Our Ref: 497DA228 (I1/908) STH08/01370
Contact: Andrea Boes 4221 2771
Your Ref: MP06_0209 MOD 3

**WOLLONGONG CITY COUNCIL – MP06_0209 MODIFICATION 3 – KEIRA STREET,
WOLLONGONG PROPOSED MIXED USE DEVELOPMENT**

1 ELEVATION  
CROWN STREET MALL ELEVATION 1:200 @B1

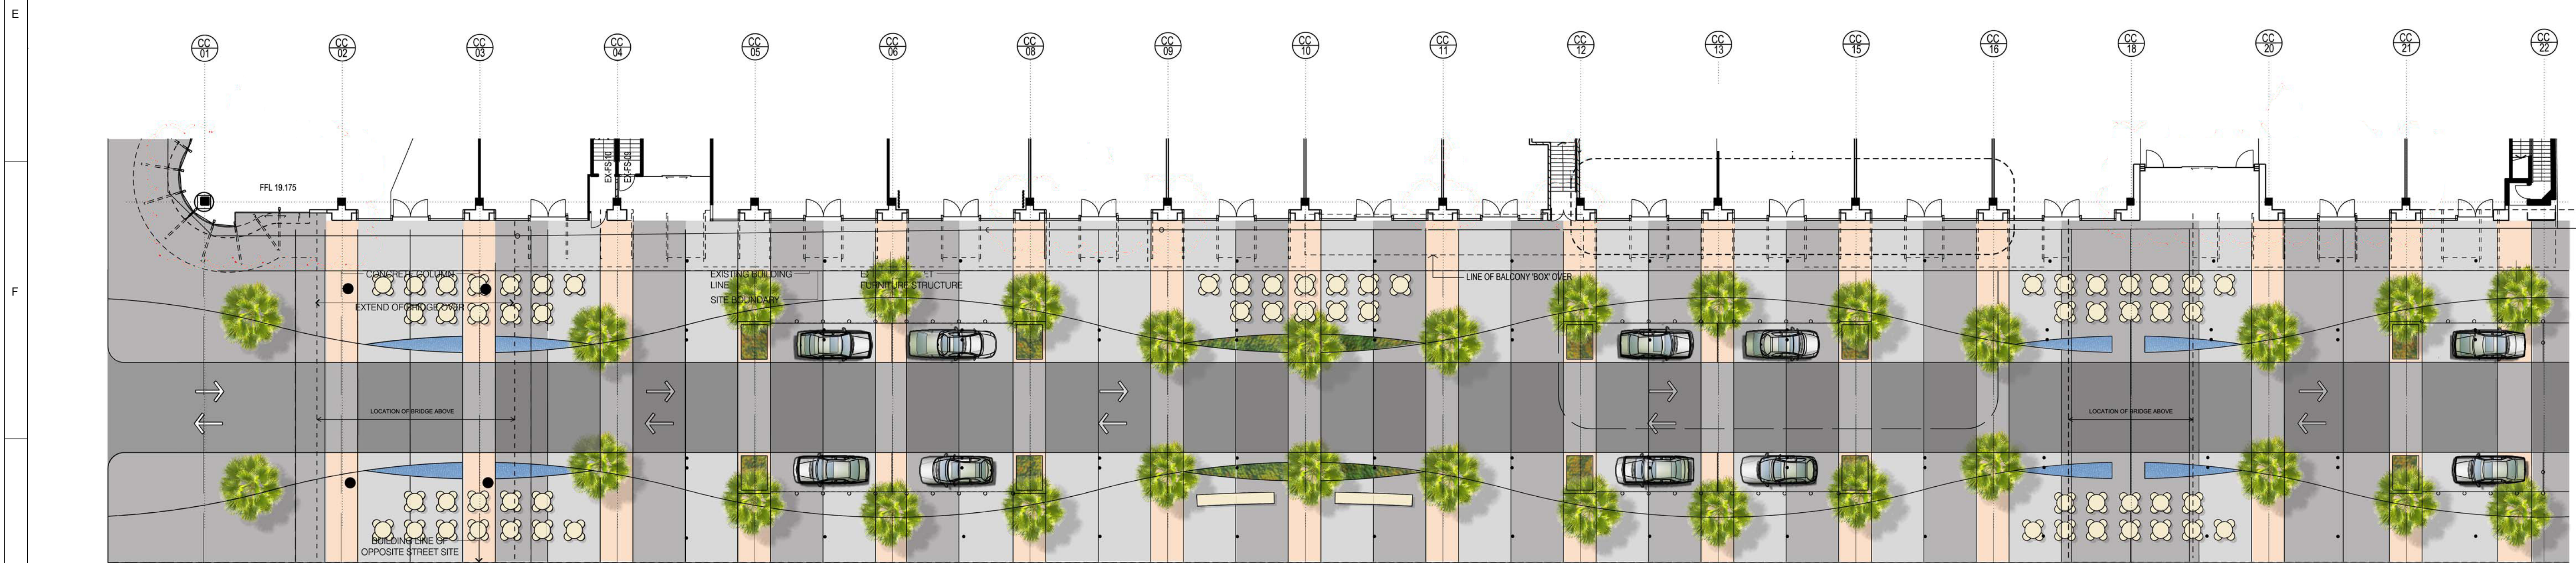
- The RTA has concerns that the graded proposed pedestrian entry off Crown Street has the potential to create road safety issues. In this regard, the RTA considers that the ramps providing access from the GPT development Retail Level 2 down to the Crown Street footpath create the potential for a collision with vehicles on Crown Street, particularly for prams and disabled users. The RTA considers this issue needs to be assessed in detail and addressed where necessary by some form of kerbside barrier. The assessment needs to include a detailed plan at this location, identifying the grades of the ramps/footpath and the location of the pedestrian crossing at the signalised junction of Crown Street/Keira Street.

1 ELEVATION
KEIRA STREET
1:200 @B1

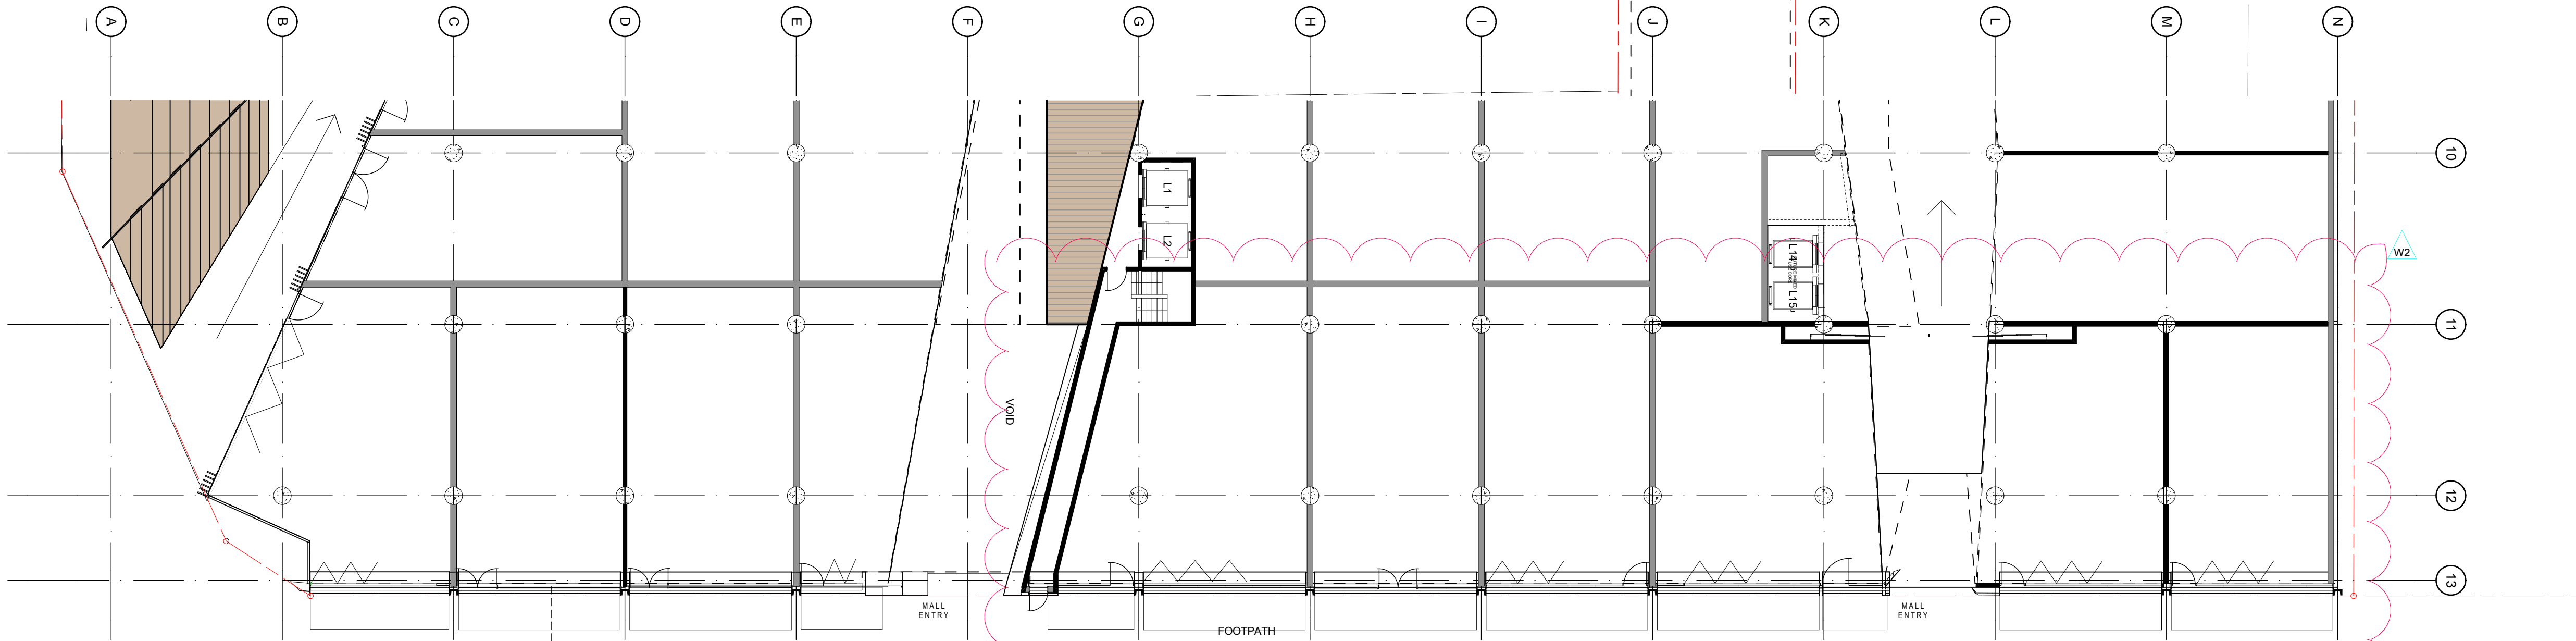
- The RTA does not believe that the development adequately provides for public transport, particularly in light of the recent modifications to the bus stops within the Wollongong CBD. Specifically, the proposal has not adequately catered for the relocation of the northbound bus stop from the Transit Mall to outside of the existing Bing Lee Development. The West Keira Development represents a major development in Wollongong CBD that will draw large numbers of people to the CBD and as such the RTA considers that the proponent must provide appropriate public transport infrastructure. Based on all of the above, the RTA would not support the proposal unless the following issues were addressed by the proponent:

- Provision of a widened footpath at the bus stop to adequately accommodate pedestrians travelling north south along the western side of Keira Street and the provision of bus shelters to accommodate the bus passengers waiting to catch a bus. This may require indentation within the proponent's site.

- The bus shelters should be in accordance with the attached designs identified in a joint study between the RTA and Council titled "Wollongong CBD Bus Interchange Passenger Infrastructure Upgrade". In this regard, the bus shelters are to be located adjacent to the kerb with a pedestrian footpath of suitable width between the shelters and the building façade.

A plan showing how these issues will be addressed should be provided to the RTA prior to determination.
